Information for Condition 6 and 7 of Planning Approval Ref: H14-0948-24

Provided by VSA on behalf of Stagecoach Services Limited

Stagecoach Spalding Depot

Responses to Lincolnshire Fire and Rescue Letter dated 25-02-2025

Clean Water Plan A4

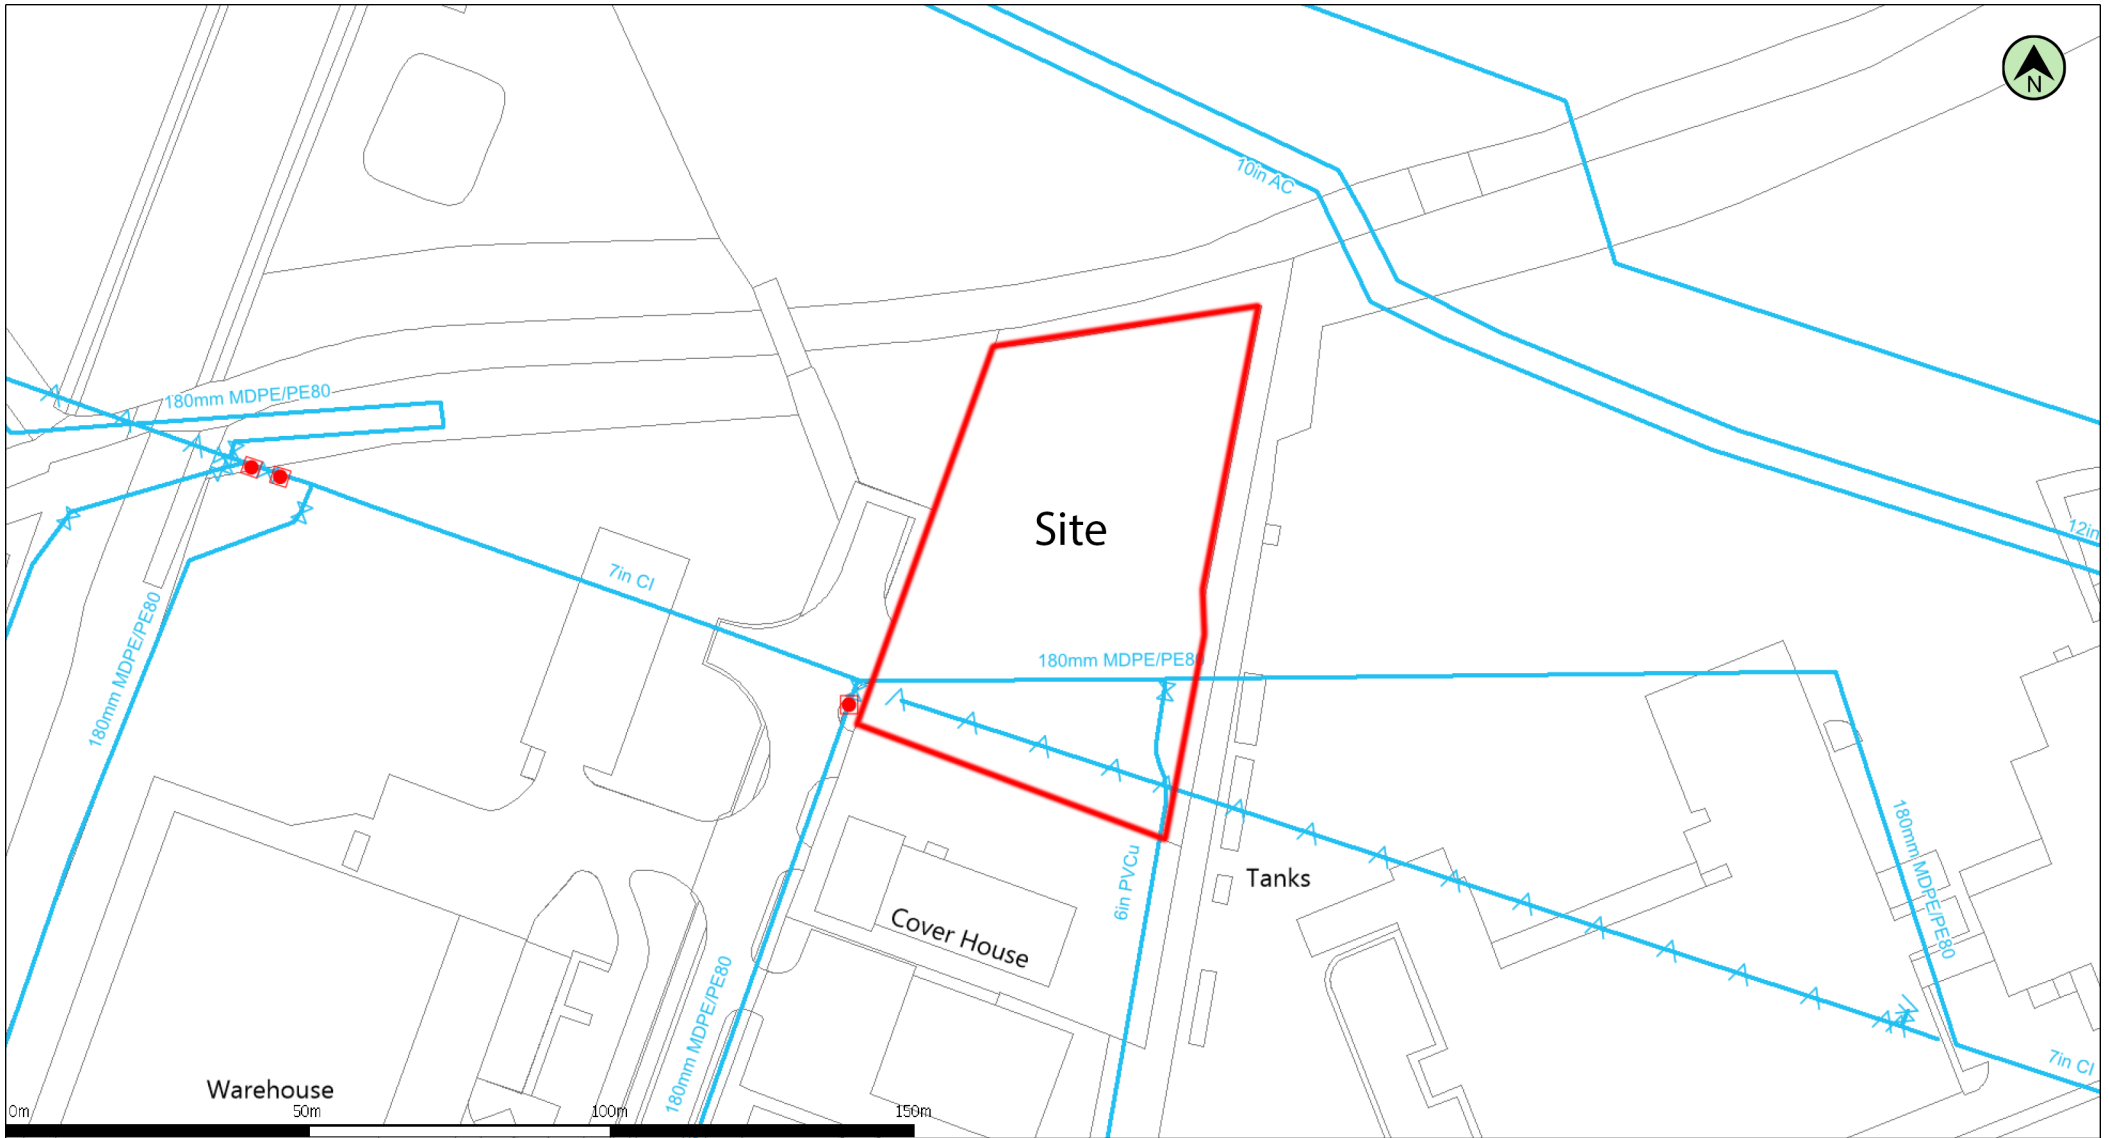
- One fire hydrant will be required no more than 90 meters away from an entry to the site.

The existing fire hydrant within the public footpath is 8m from the vehicular entrance to the site and 45m to the portable office building within the site.

The Fire Hydrant is on the Public Footpath.

Please refer to Dwg: 1454489_A4_Clean Water and Fire Hydrant

DATE	OCT. '24	SCALE 1:200	DRAWING NO. SW24-219-120	REV. C
DRAWN	MP

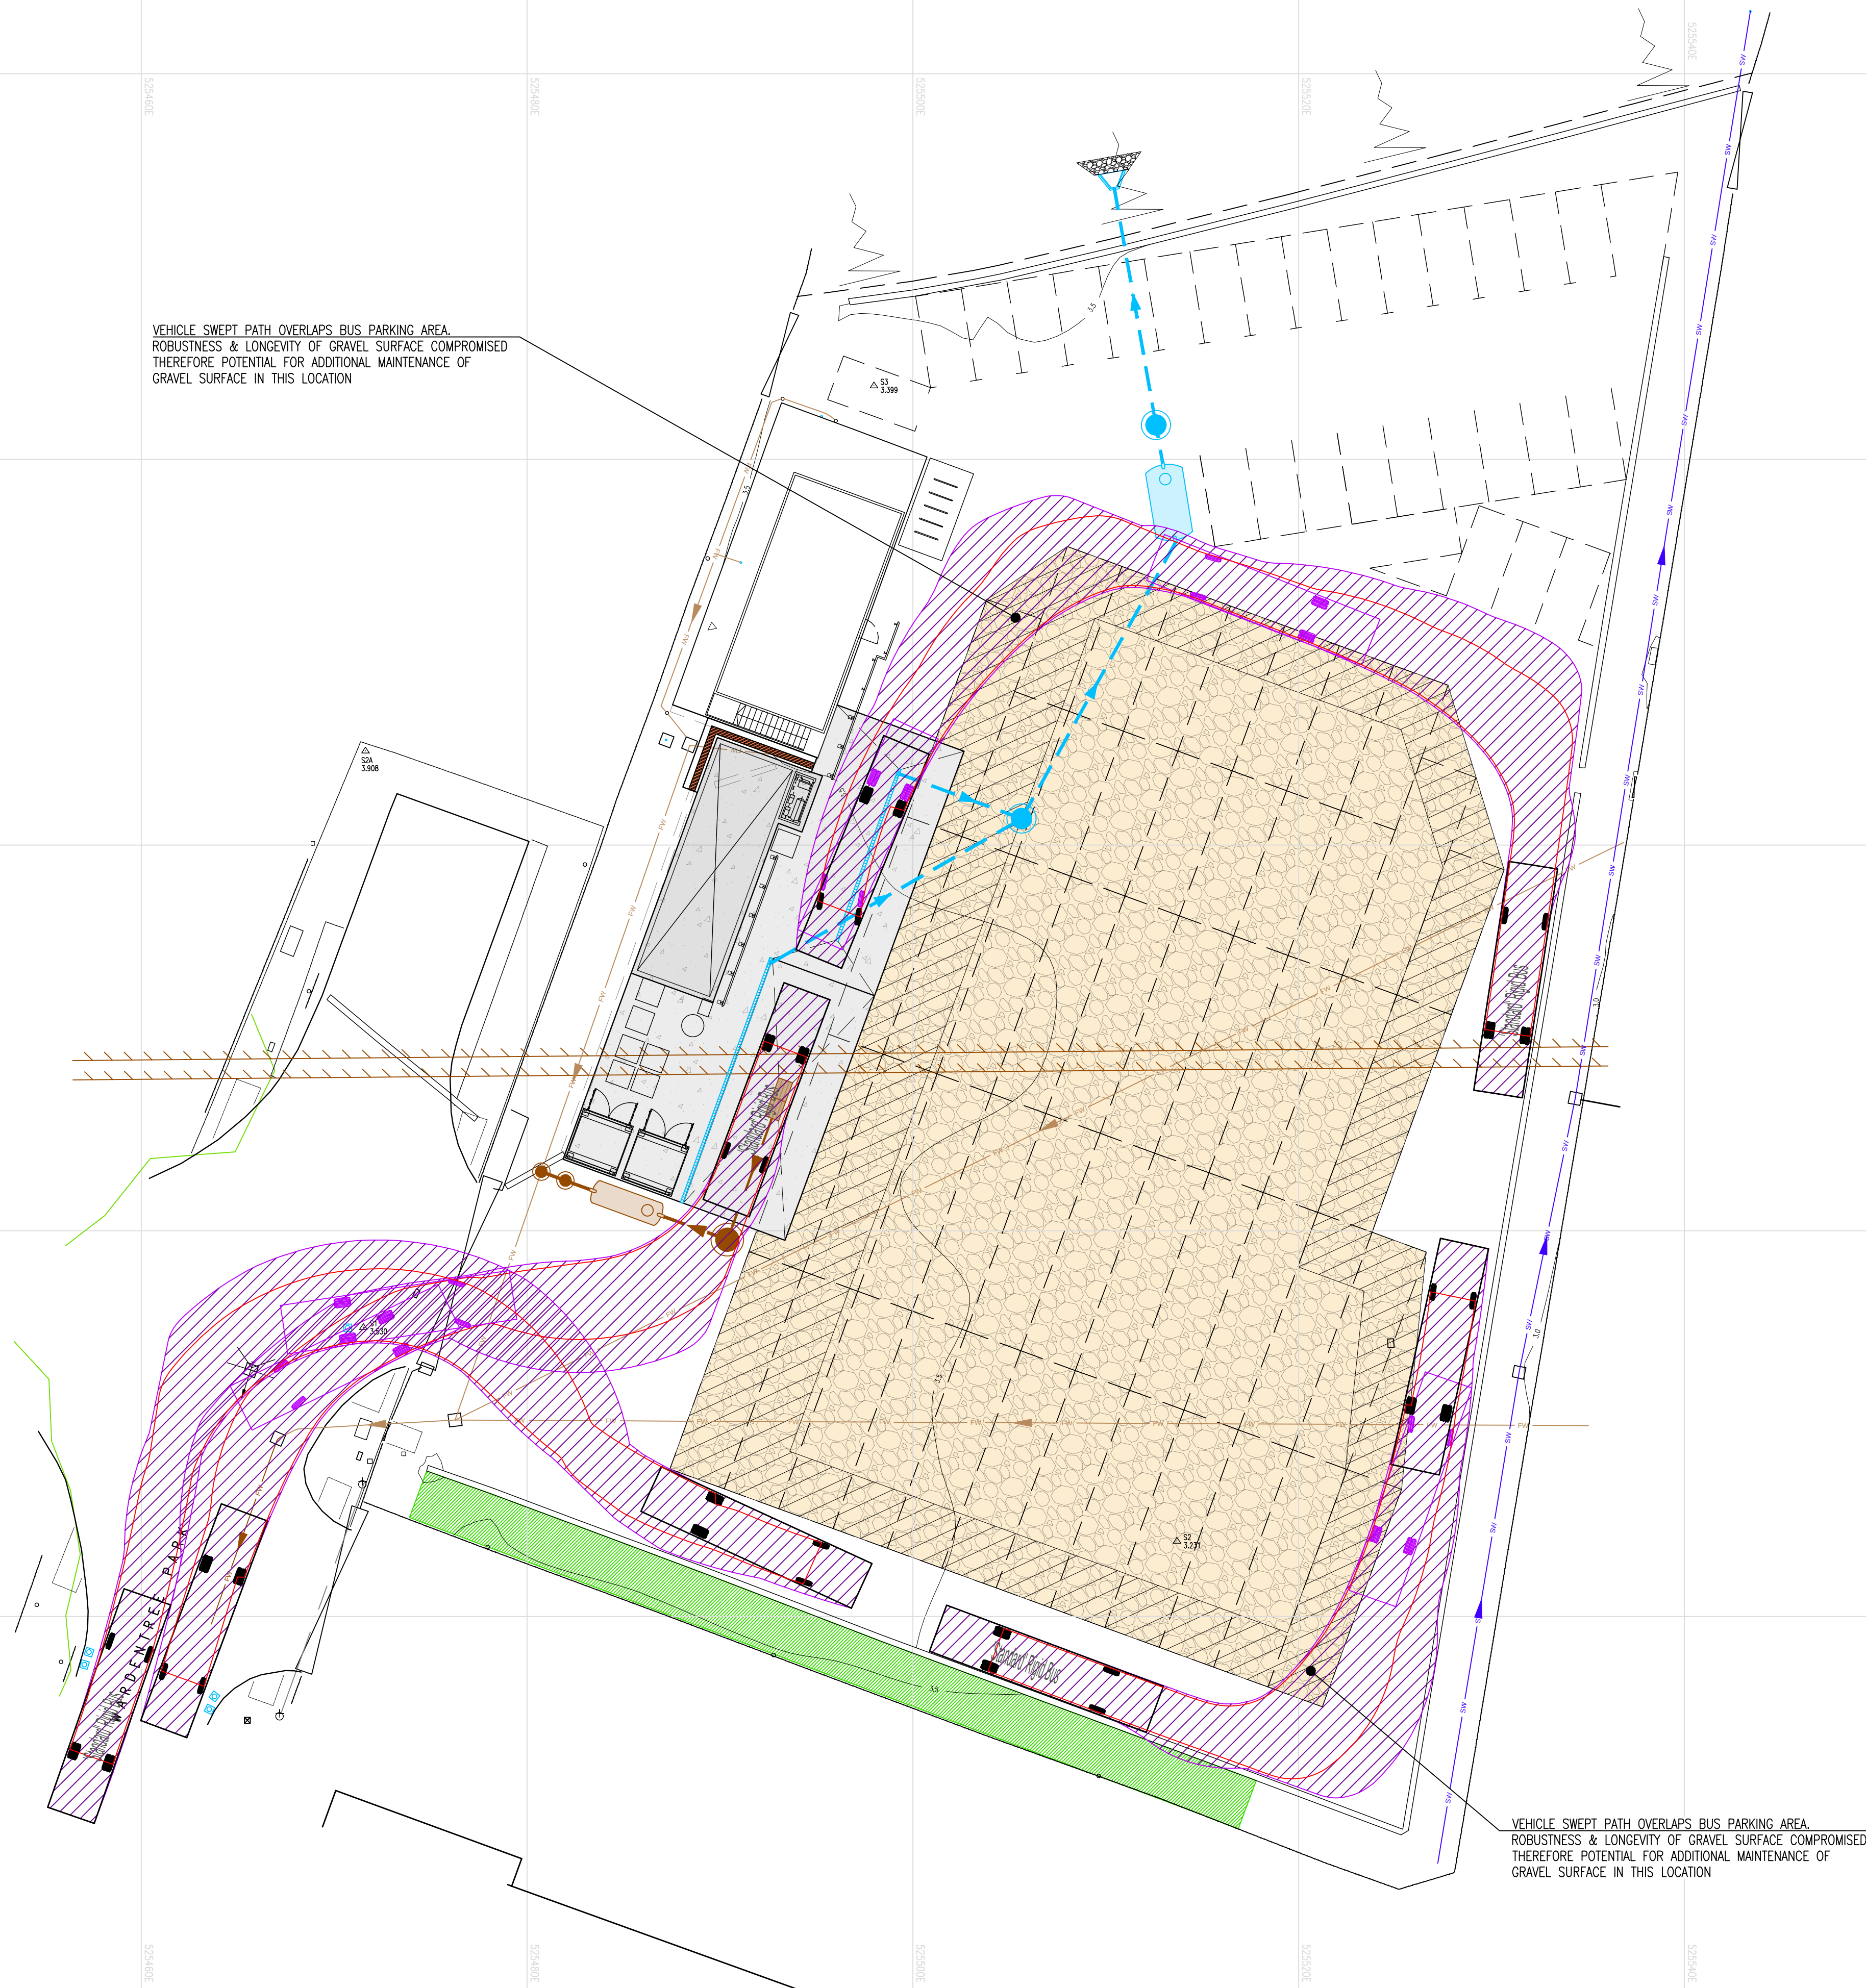
- Access should comply with the Building Regulations 2010 (as amended), Part B5.

The Vehicular access can be accessed by Buses and therefore can accommodate a fire tender. Please see dwg: SW24-219-120C - Vehicle Tracking-Rigid Bus
